**MEMORANDUM
 PLANNING AND URBAN DEVELOPMENT DEPARTMENT
 PLANNING DIVISION**

To: Sean Dundon, Chair, and Members of the Portland Planning Board
From: Nell Donaldson, Senior Planner, and Caitlin Cameron, Urban Designer
Date: October 19, 2018
Re: MMC Congress Street Hospital Building
Project #: 000331-2018 **CBL:** 53-D-7
Meeting Date: October 23, 2018

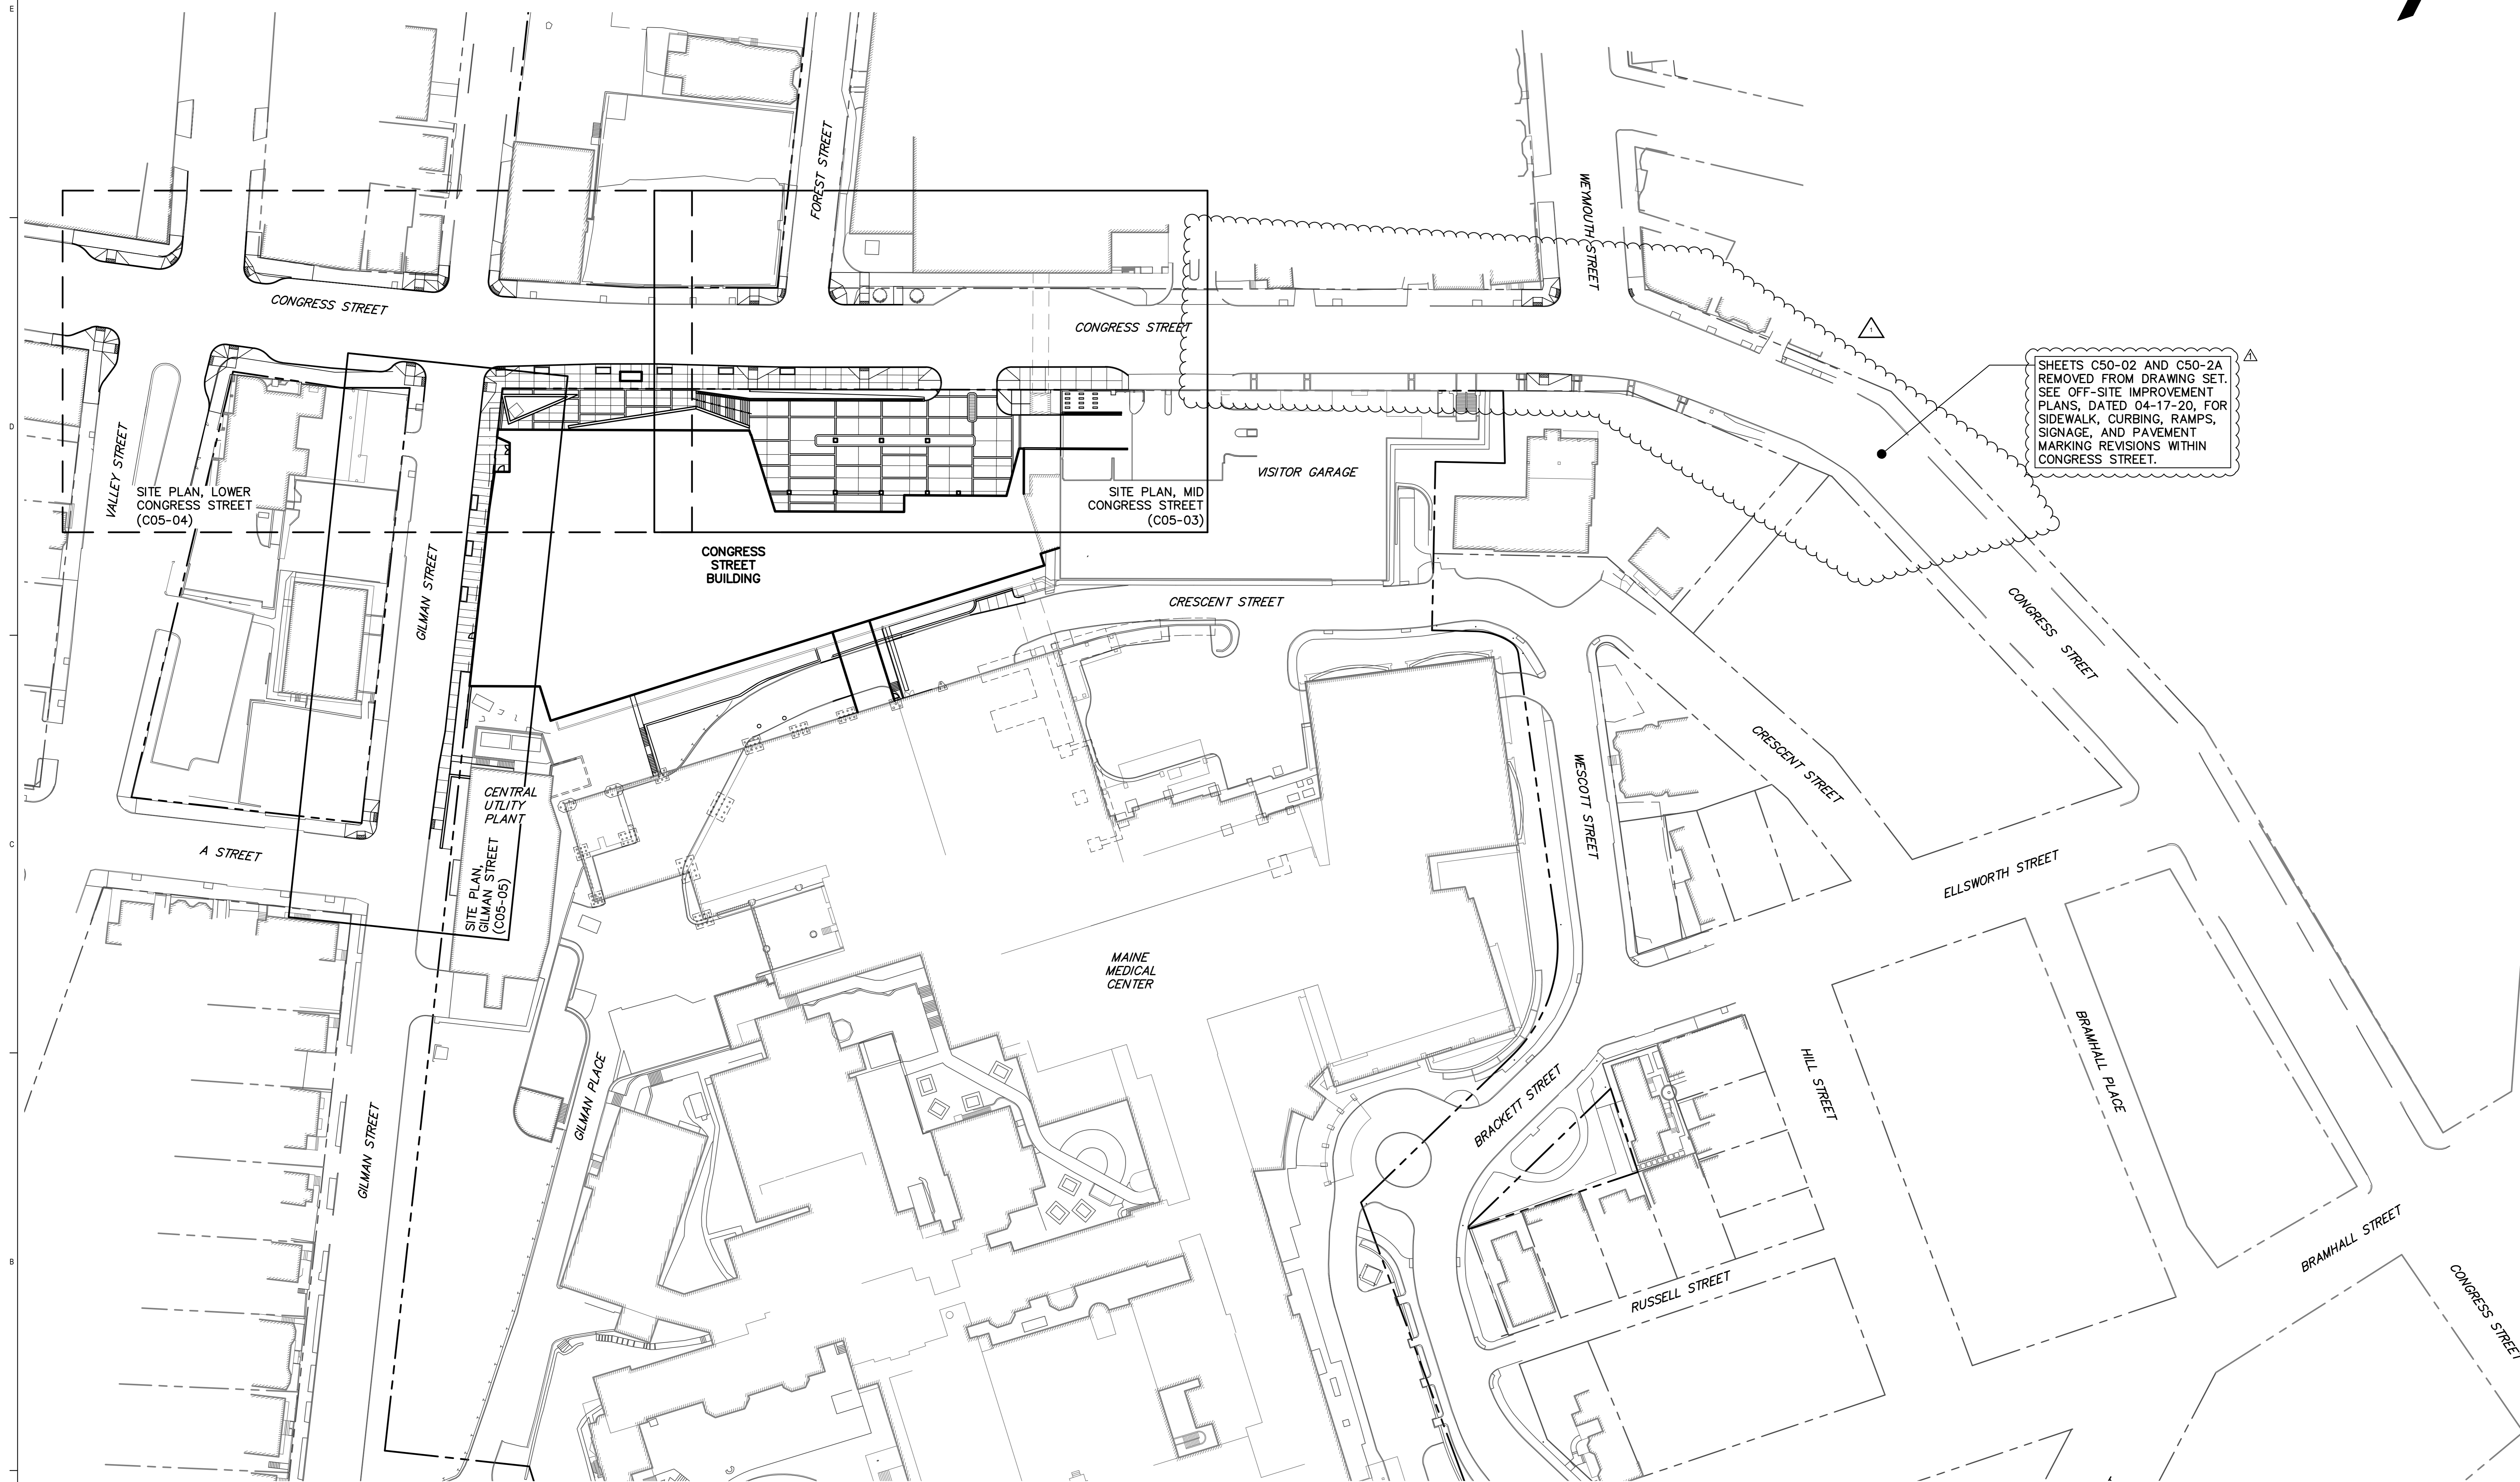
1. *Sidewalk width and sidewalk design:* The effective width of the proposed Congress Street sidewalk varies between approximately 3' at the area with a perpendicular crosswalk, 6' at areas with tree wells, and 11' elsewhere. Staff has requested that the applicant explore options to widen the sidewalk to allow more a generous pedestrian zone. Staff has also raised questions about the width of the Gilman sidewalk as it is proposed to taper near Congress. Tom Errico, the city's consulting traffic engineer, writes,

General sidewalk width given future pedestrian demand on Congress Street seems inadequate. Congress Street cross-section width should specifically be detailed. How will bikes, parking, bus, vehicles be accommodated?

The flared curb ramp near the main entrance vehicle driveway is not acceptable partly because it creates a narrow pedestrian accessible route. Also, the crosswalk location should be evaluated.

The provision of the City’s preferred two ramp configuration at the Gilman Street corner should be investigated.

The Gilman Street non-tangent curb alignment is not acceptable. A straight curb is suggested. Gilman Street width dimensions shall be provided.

I don’t believe, based on the grading plan submitted, (C40-01/02) that the curb ramps serving the mid-block crosswalk meet ADA in terms of cross-slope (2% max. cross-slope) nor that the area shown for the bus stop has a bus landing area that meets ADA. Please document the ADA analysis.

I need to further assess curb ramp design- for instance, there is not sufficient landing area for the curb ramp serving the mid-block crossing along the retaining wall - a 5’ deep (measured perpendicular to the street) ramp landing area is required where a ramp meets vertical obstructions (not the usual 4’)

Existing Signage Location Plan

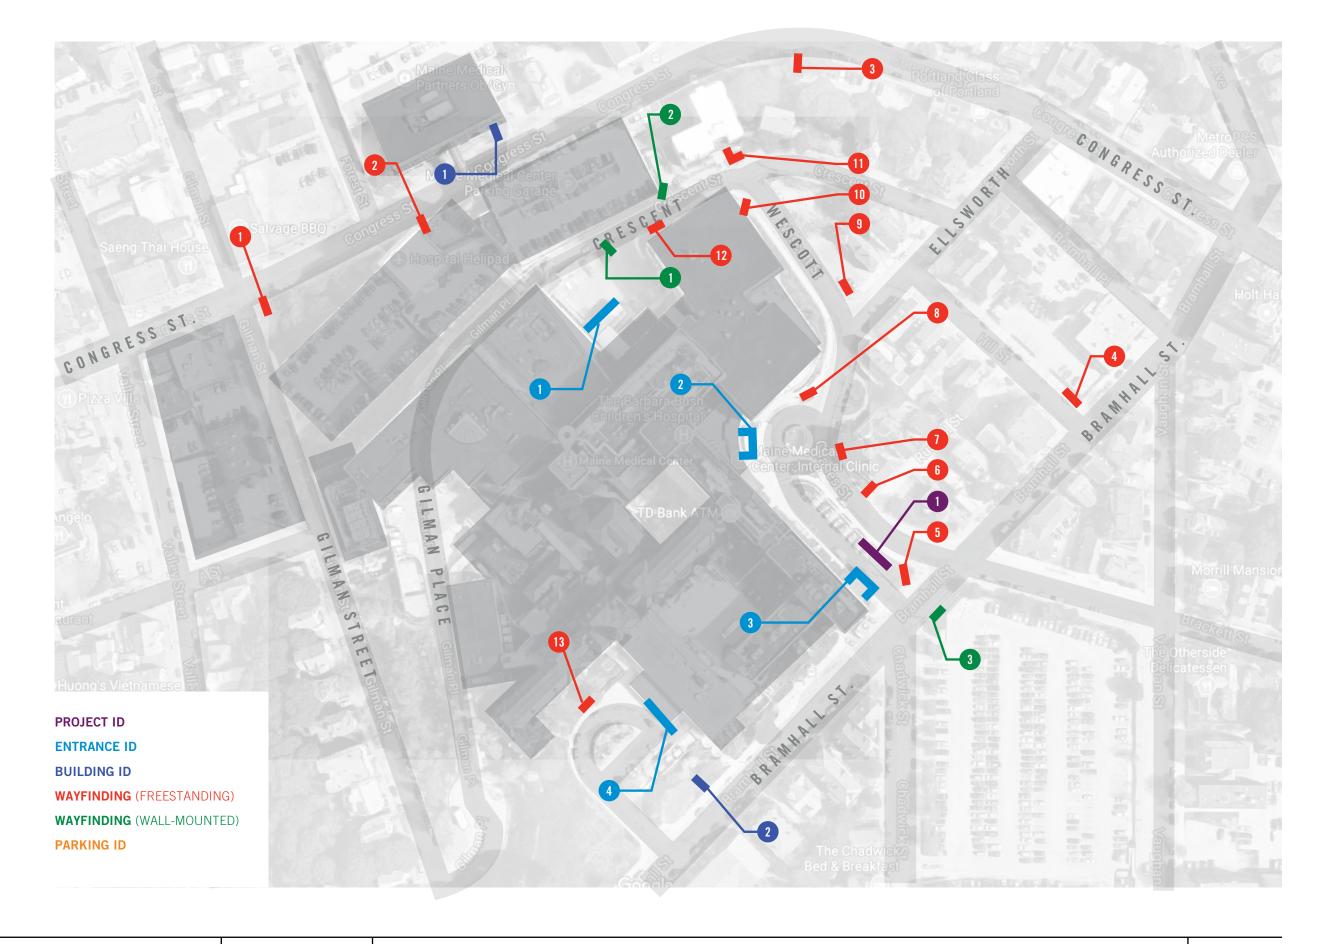
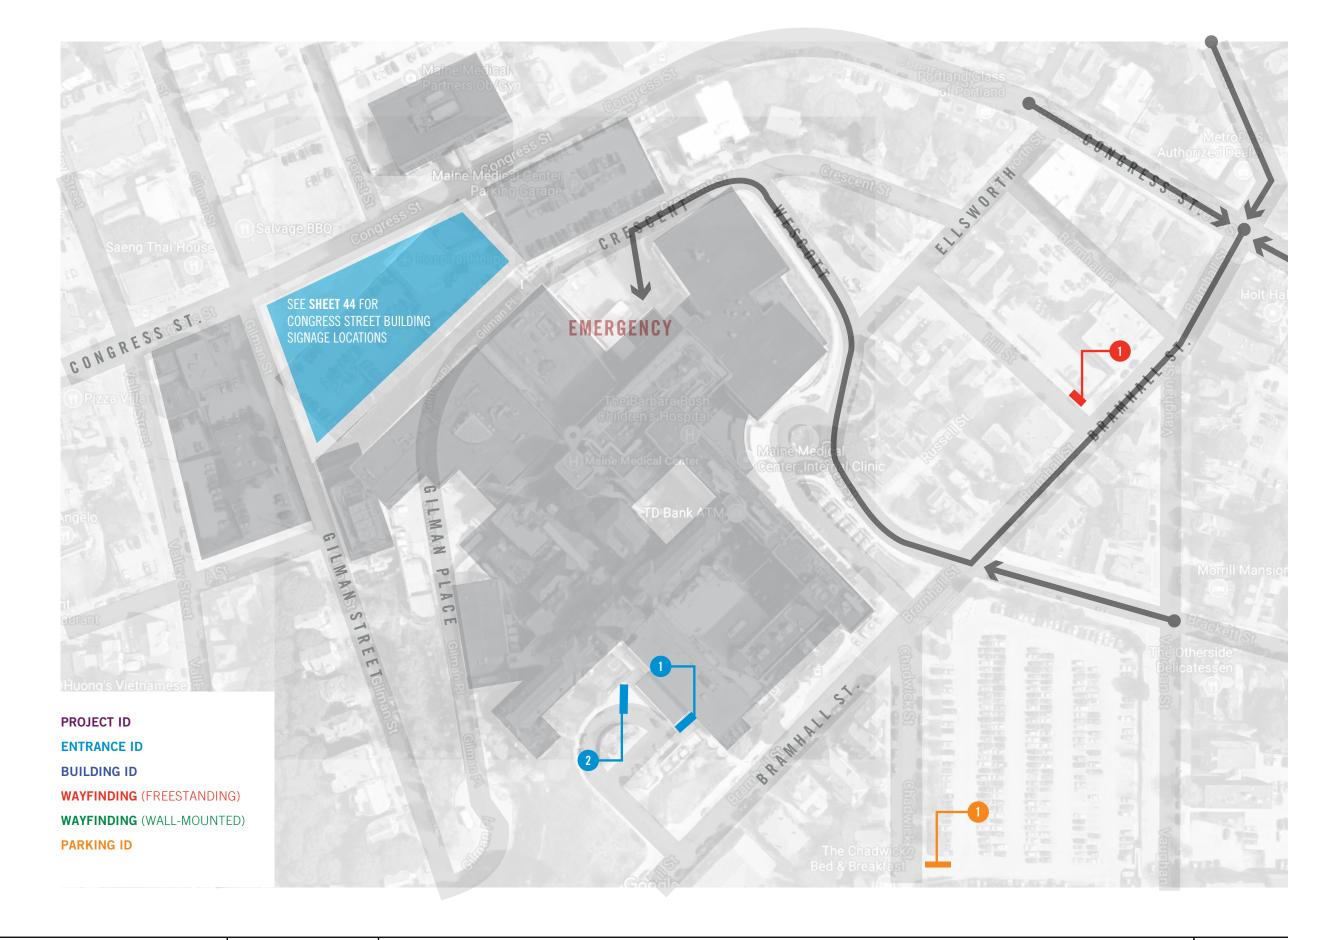
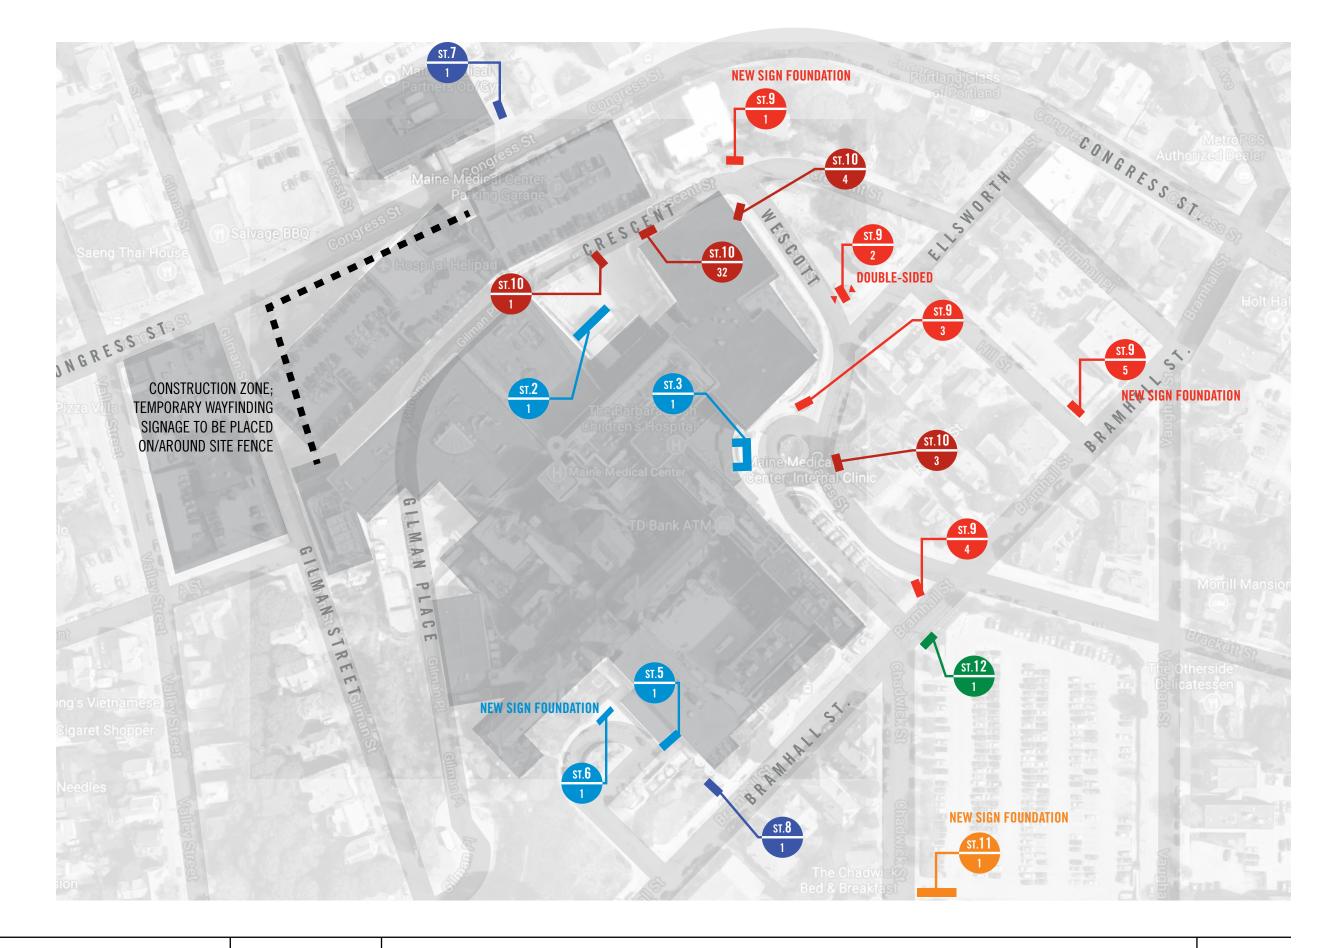
Regarding the new sign proposed at Bramhall Square, signs will not be permitted on properties not owned by MMC. This should be removed.

There are concerns about sight line obstructions on several of the signs located at driveways and intersections. Staff requests a sight line analysis.

There are concerns about the height of some monument signs shown at 11’0” tall next to sidewalk locations. Sight lines and pedestrian scale are factors here.

CS.2 Site Line Analysis

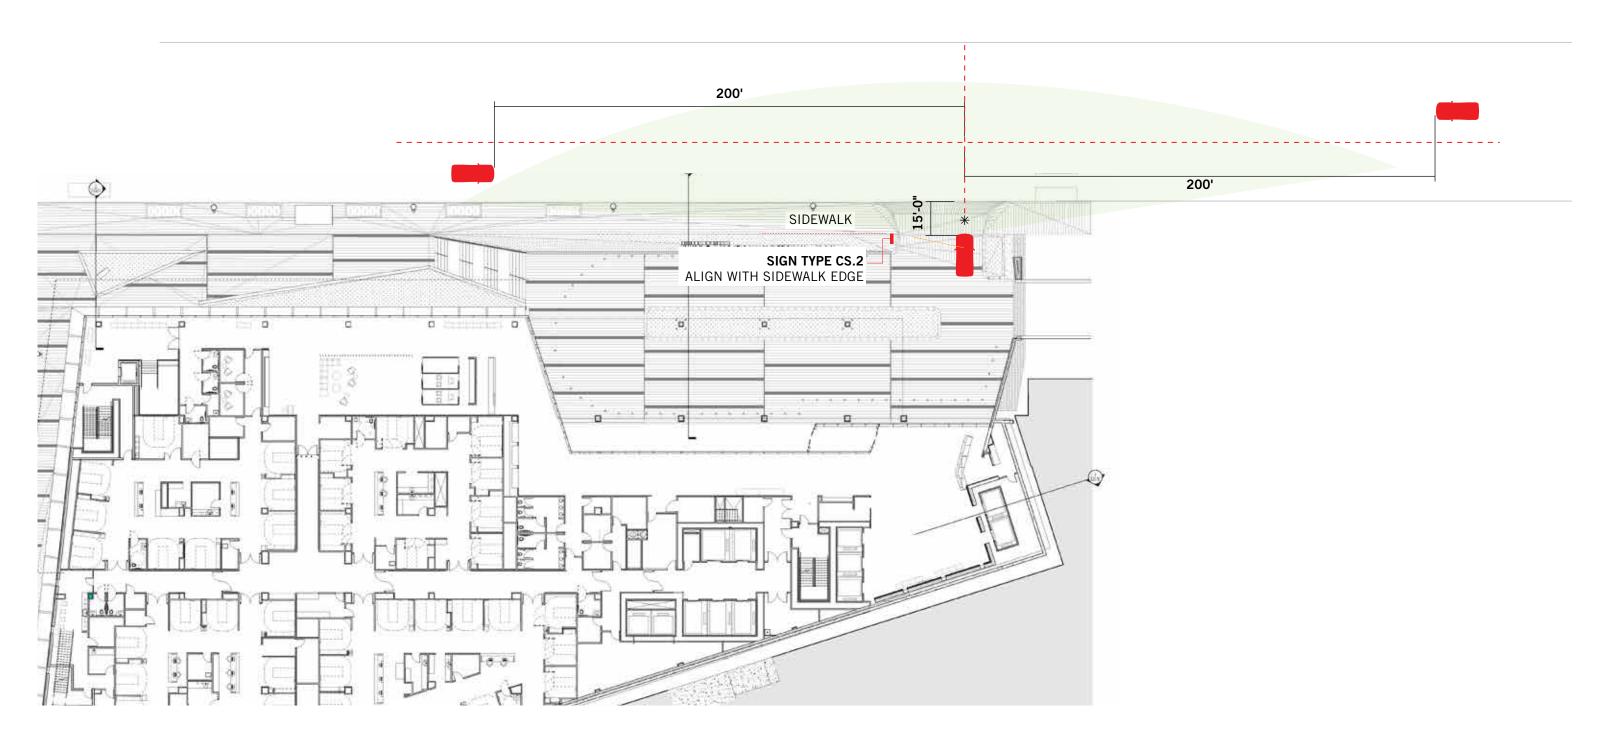
- i. *South parking lot signage: Two signs facing the same street are not appropriate, not necessary, and create too much visual clutter. Eliminate one of the signs (5.b). Reduce the overall size.*
- ii. *CS.1: What methods of illumination are proposed for this large sign on Congress Street?*
- iii. *EG.1: The layout of this sign differs from the other monument signs on the main campus. Is there a reason for this? Concern is for overall consistency and comprehensiveness.*
